Bayside Council

16 February 2018

Re: Bayside Council Response to Modification Eastlakes Shopping Centre (MP 09_0146 MOD 3)

Figure 3 – Proposed Landscape Plan

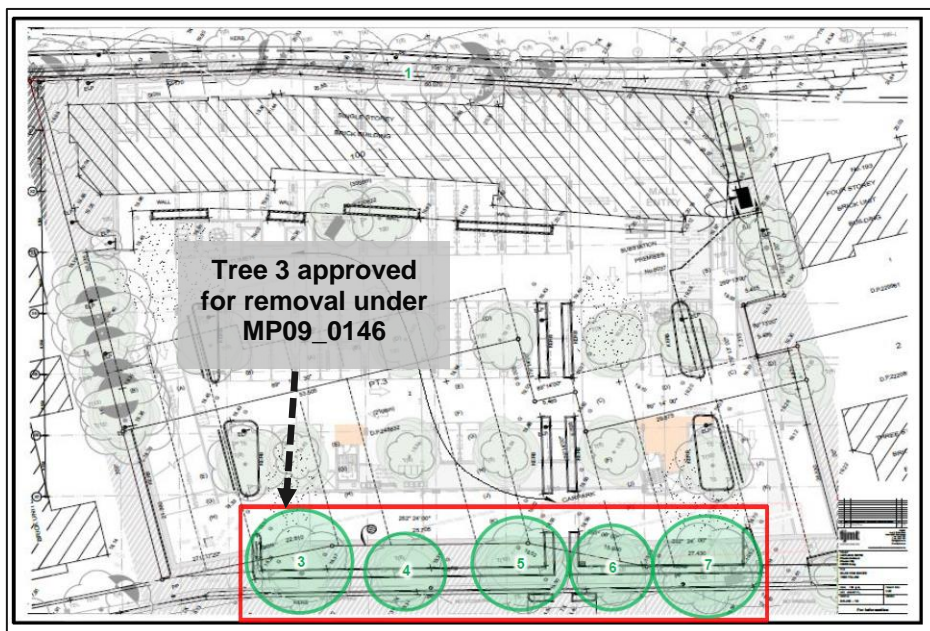
As such consent is granted for the removal of the remaining four *Platanus* located along the northern side of Evans Avenue. Council, however, request the replacement species are either *Platanus x acerifolia*, London Plane Tree which is the proposed street tree for Evans Avenue in City of Botany Bay Street Tree Master Plan 2014, or Spotted Gum tree (*Corymbia maculata*), due to its lower maintenance requirements, Council is aware, however, the awnings may have an impact on the viability of the Spotted Gum tree and therefore will allow the applicant’s Landscape Architect to make the final decision.
